FIVE ESTUARIES OFFSHORE WIND FARM

10.18 REPORT ON PROPOSED CHANGES

Application Reference:	EN010115
Document Number:	10.18
Revision:	A
Pursuant to:	Change Request
Eco-Doc Number:	005409040-01
Date:	October 2024

DRAWING NUMBER: **005023882-01**
 APFP Regulation: 5(2)(a)
 Sheet No: 12 of 20

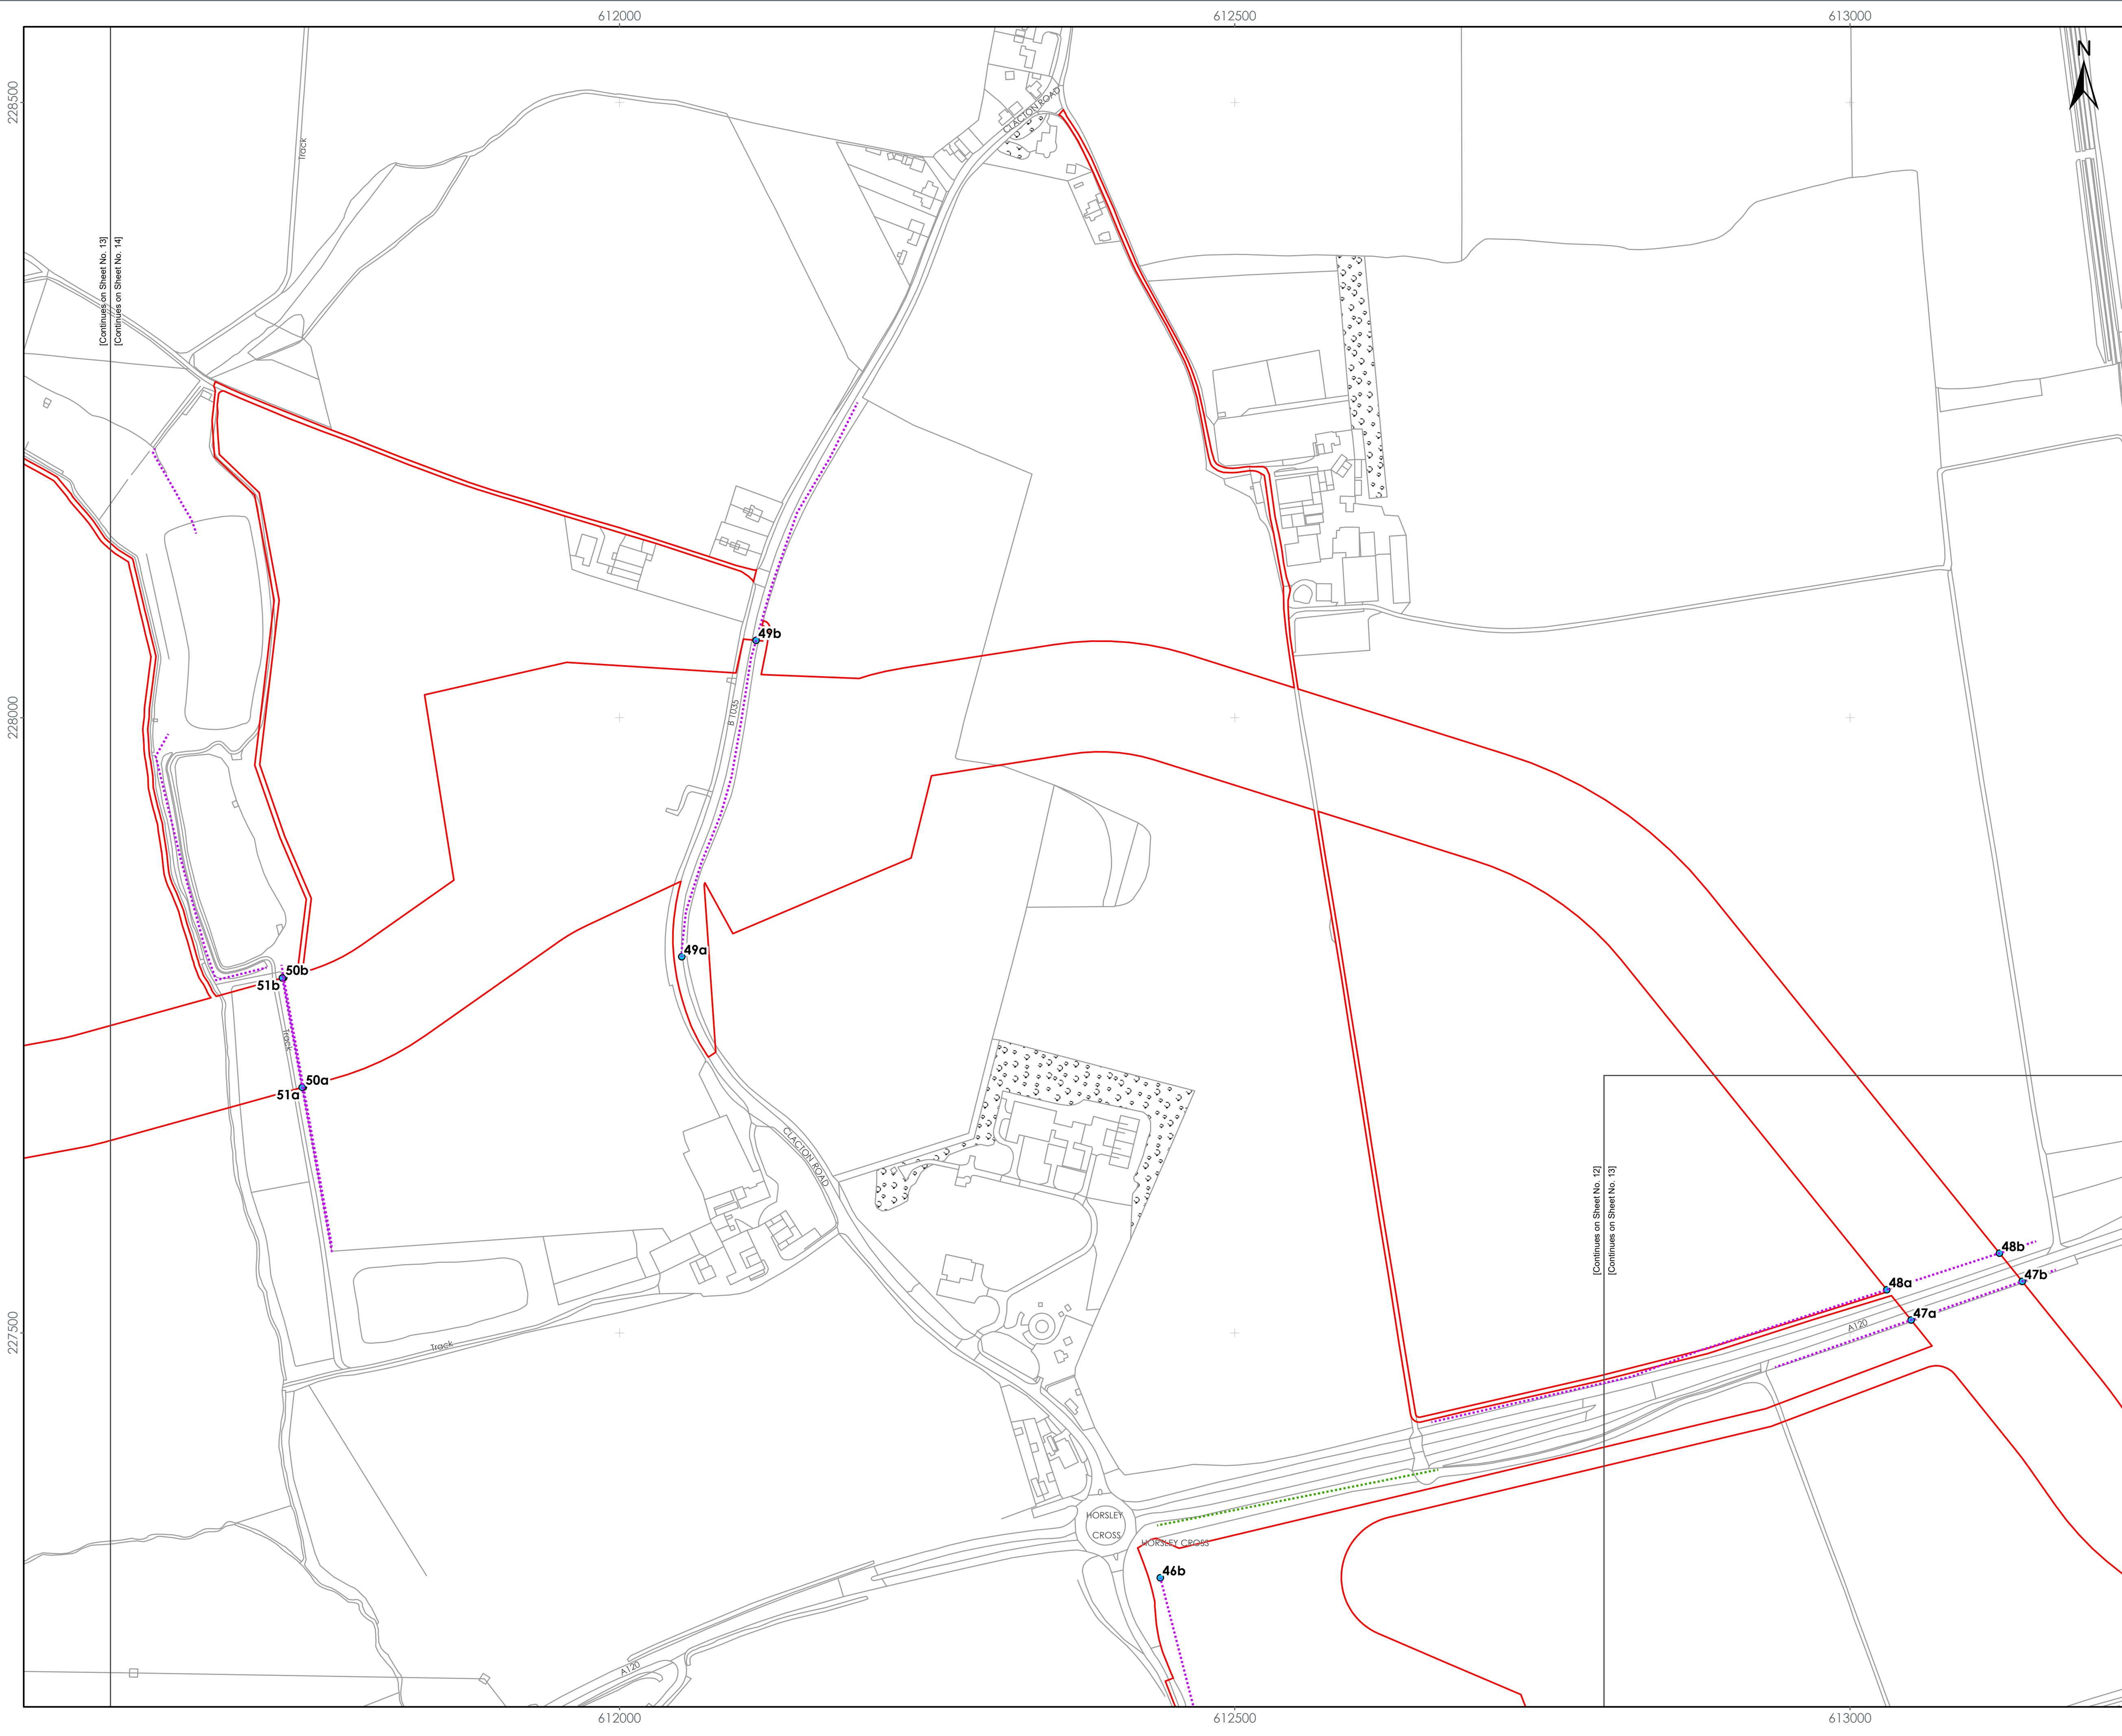
2.9.1 The powers to impact trees with existing Tree Preservations Orders (TPO) were not included in the dDCO [APP-024]. The TPOs are shown on 2.10 Tree Preservation Order and Hedgerow Plan [APP-015] Sheet 12 of 20.

2.9.3 The dDCO [REP1-008] has been updated in Revision C at Article 38 a to include amended wording to authorise works to protected trees and the new part 1 in schedule 12 lists the relevant orders and trees affected.
